DECISION DELEGATED TO HEAD OF PLANNING

Application No: H16-0209-25 **Applicant:** Castle Events Ltd
Proposal: Removal of tiered benching viewing gallery in the old courtroom
Location: The Sessions House Sheep Market Spalding
Terminal Date: 2nd September 2025

PROJECT TITLE Proposed Removal of Tiered Veiling Gallery	CLIENT Castle Events Ltd, The Sessions House, Sheep Market, Spalding	CHK BY ---	DRAWN BY CLA
DRAWING STAGE Planning	SCALE 1:50 @ A1	STAGE PLN	REV D
SHEET TITLE Plans as Proposed	PROJECT NUMBER PE11-4138	REV D	SHT 003

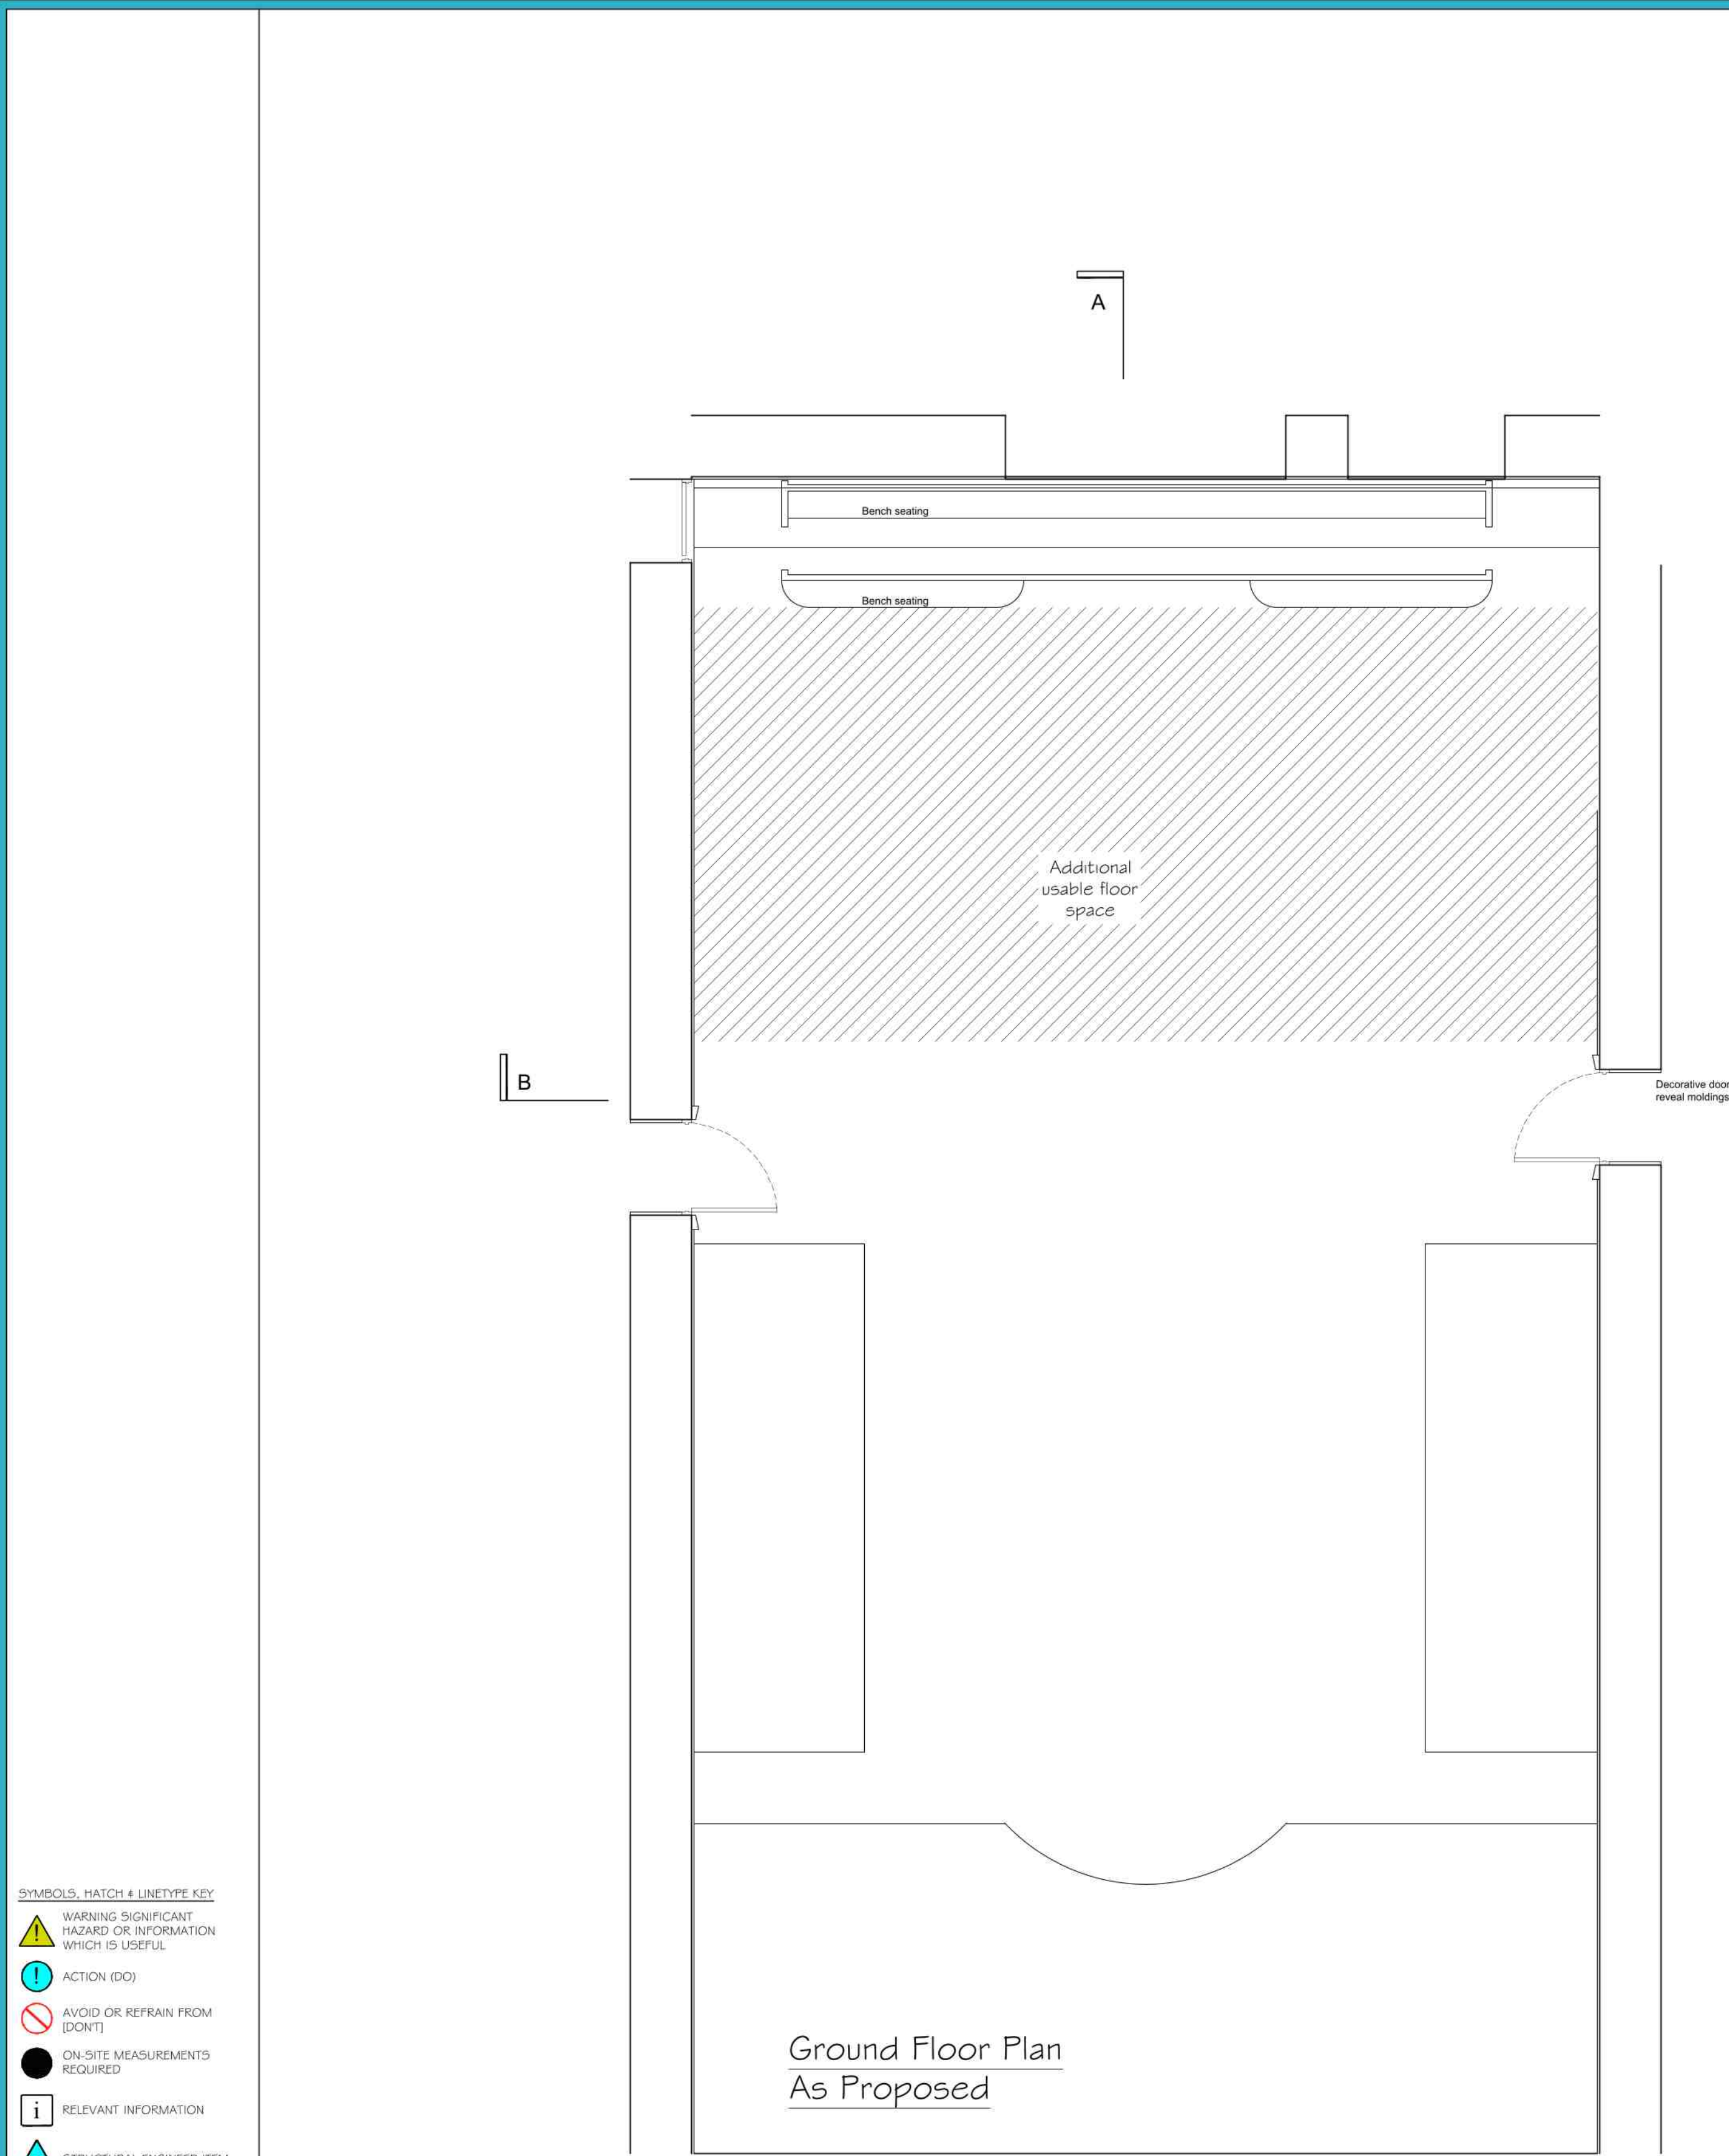
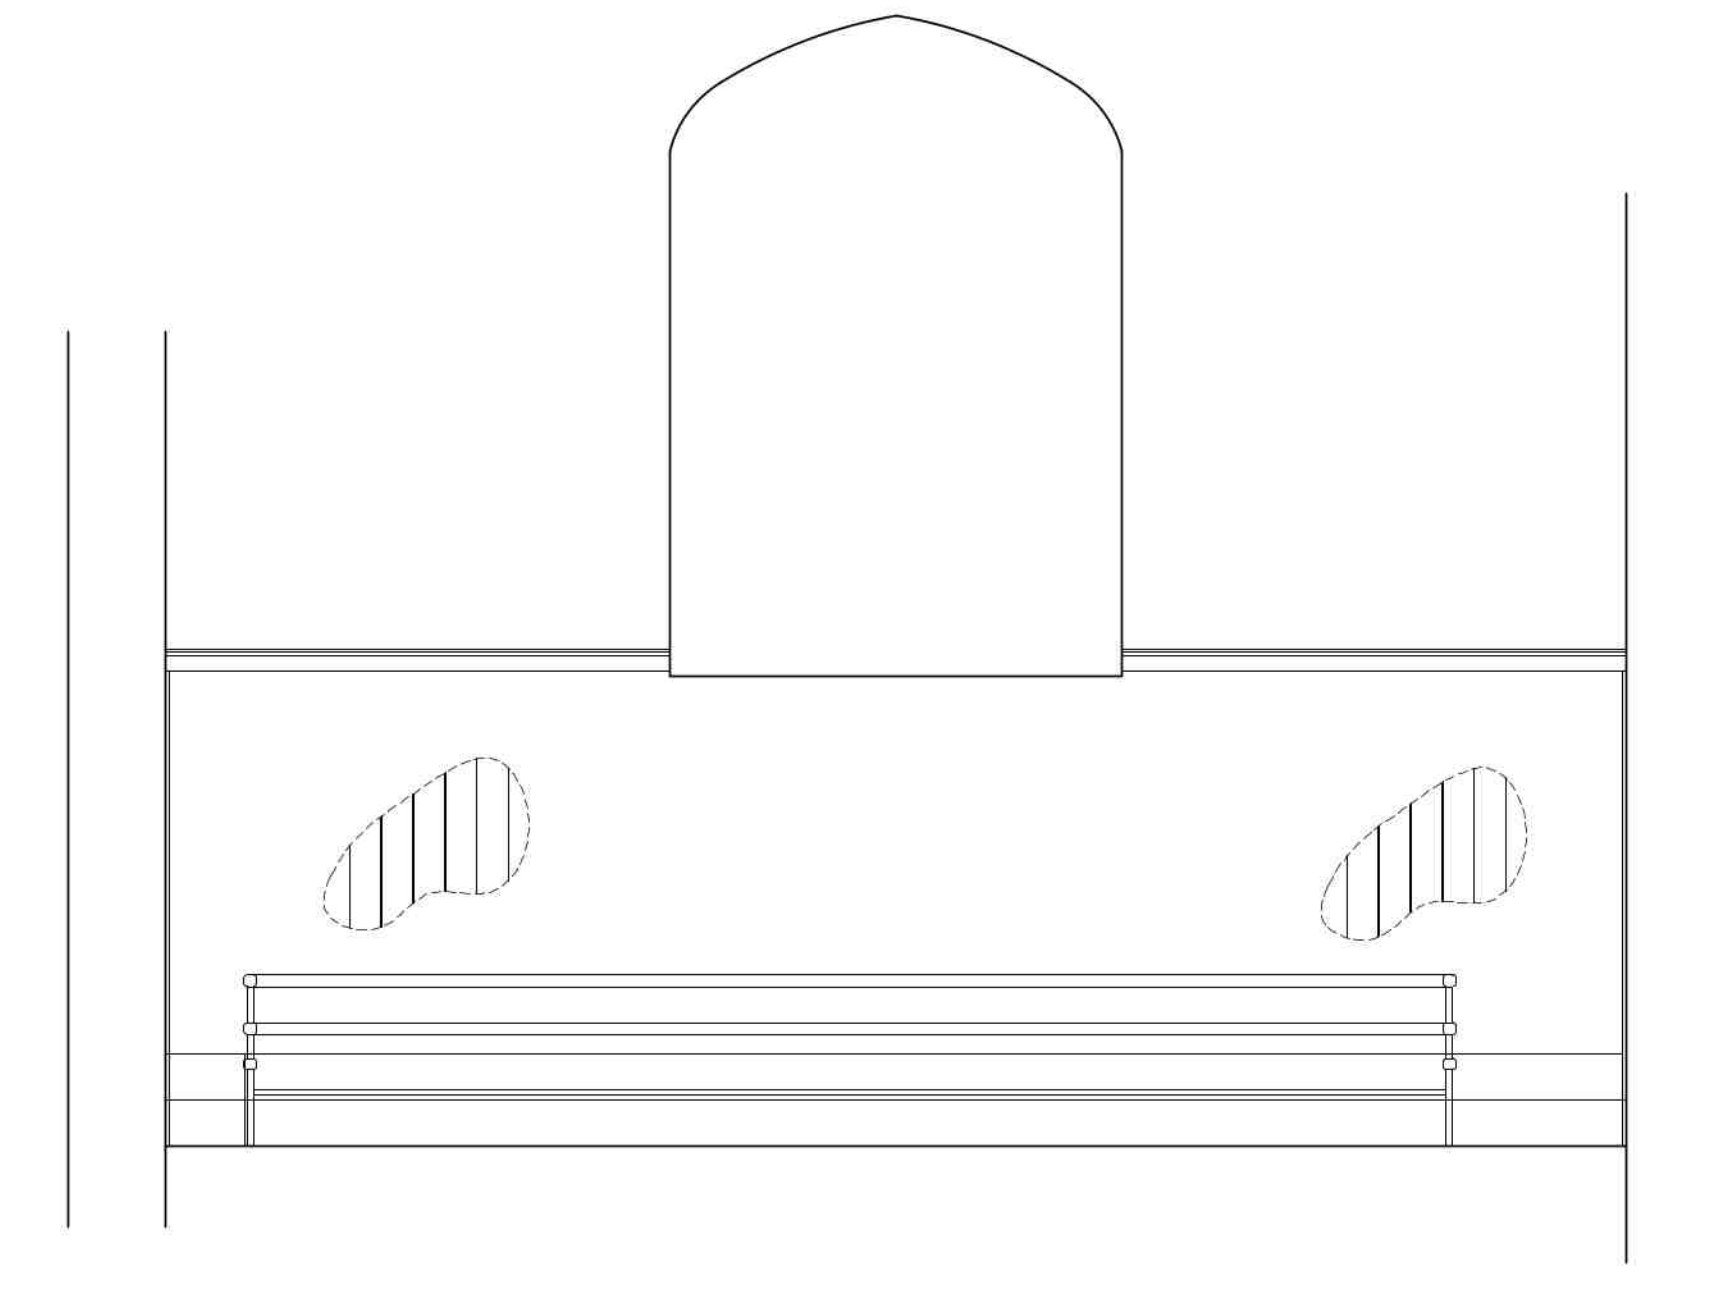
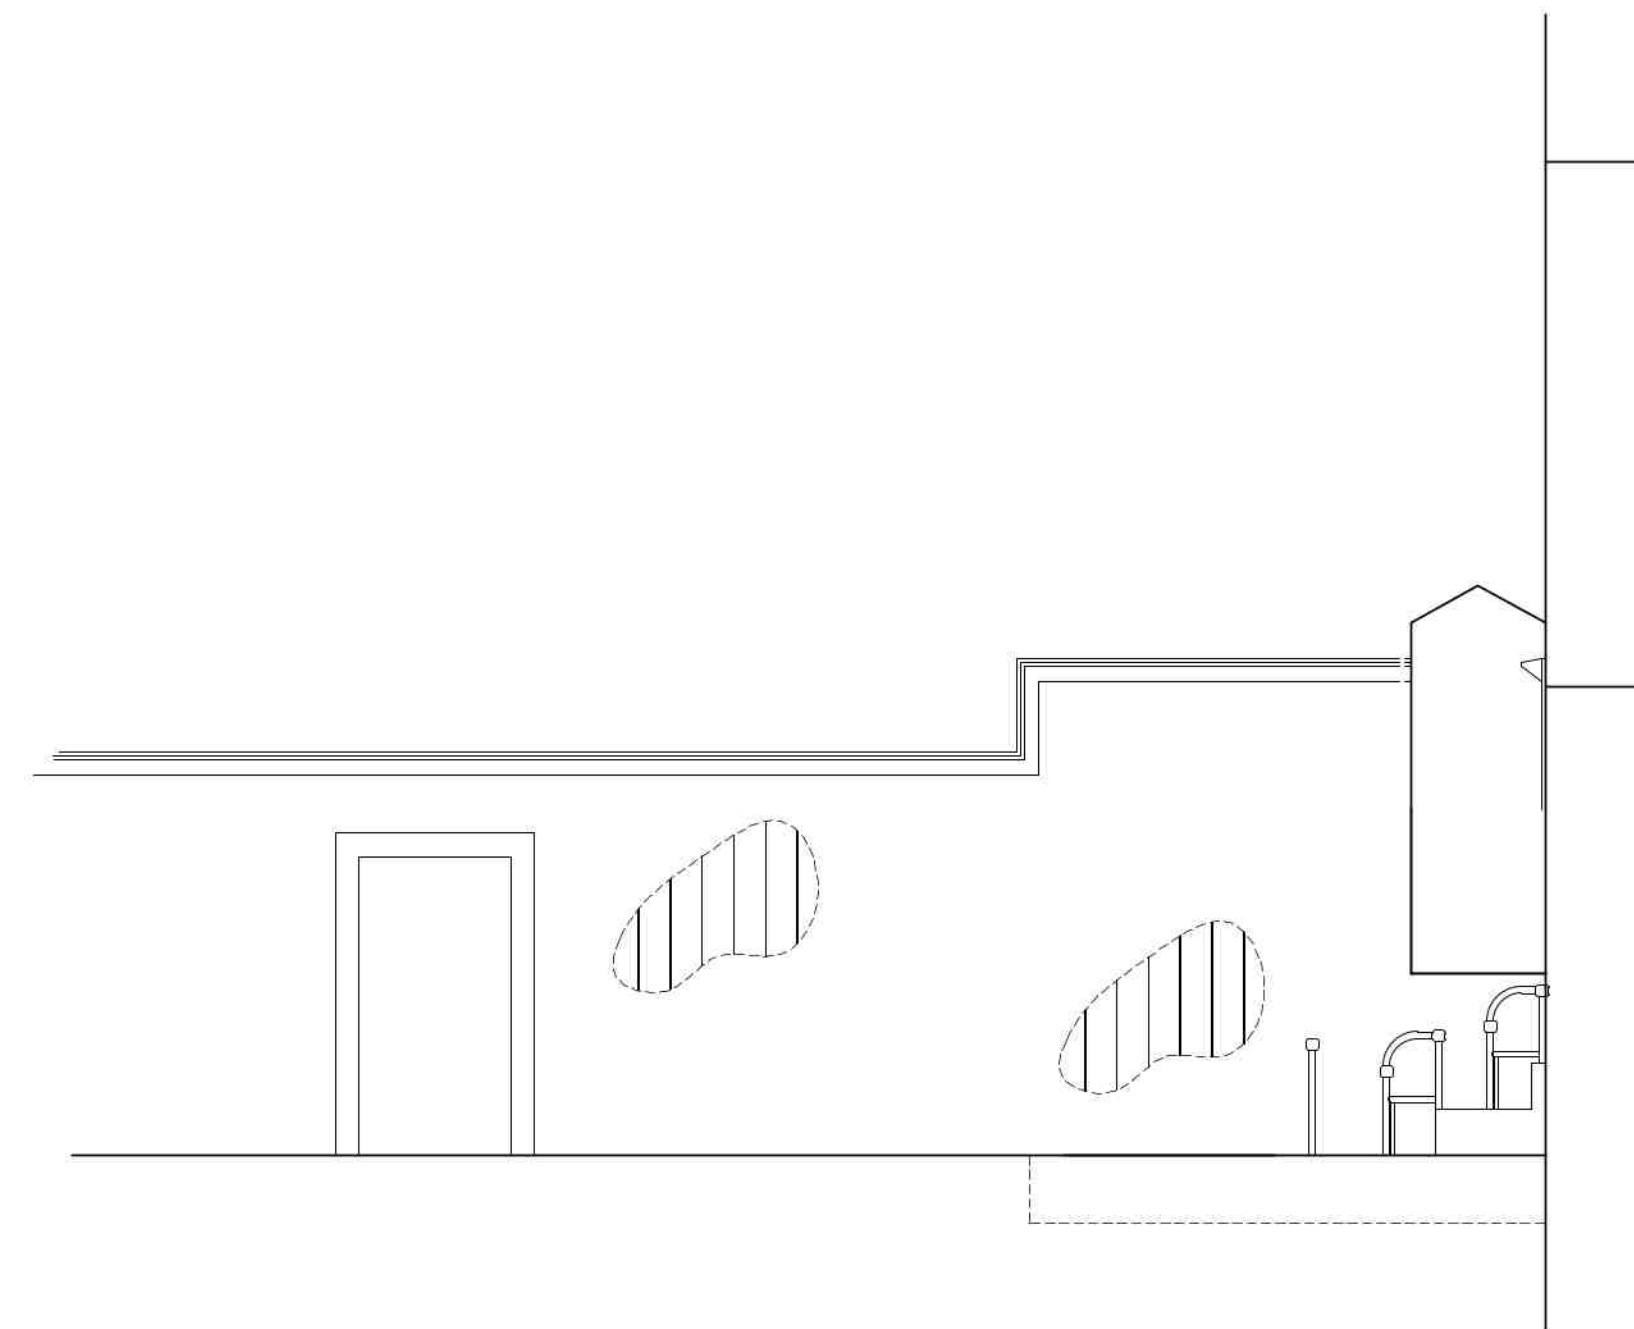
As part of the the JCAS consultation, HB&P were consulted. Whilst the HB&P did not object, they raised concerns with the appearance of the courtroom once the 'store room' were to be removed as it would create an asymmetrical appearance by introducing the store room window into the wider courtroom. The HB&P recommended an options appraisal and an updated HIA to be submitted.

HB&P raised concerns about the potential of introducing asymmetry into the courtroom by removing the tiered seating as the non-original interview room window on the Northern side of the west elevation would be exposed. This is true. However, the room is already asymmetrical due to the very existence of the interview room in the first place, and so I cannot assess that asymmetry would be unduly harmful compared to the extant. The applicant does propose mitigation by reinstating the timber panelling down to floor level on all then-exposed wall surfaces.
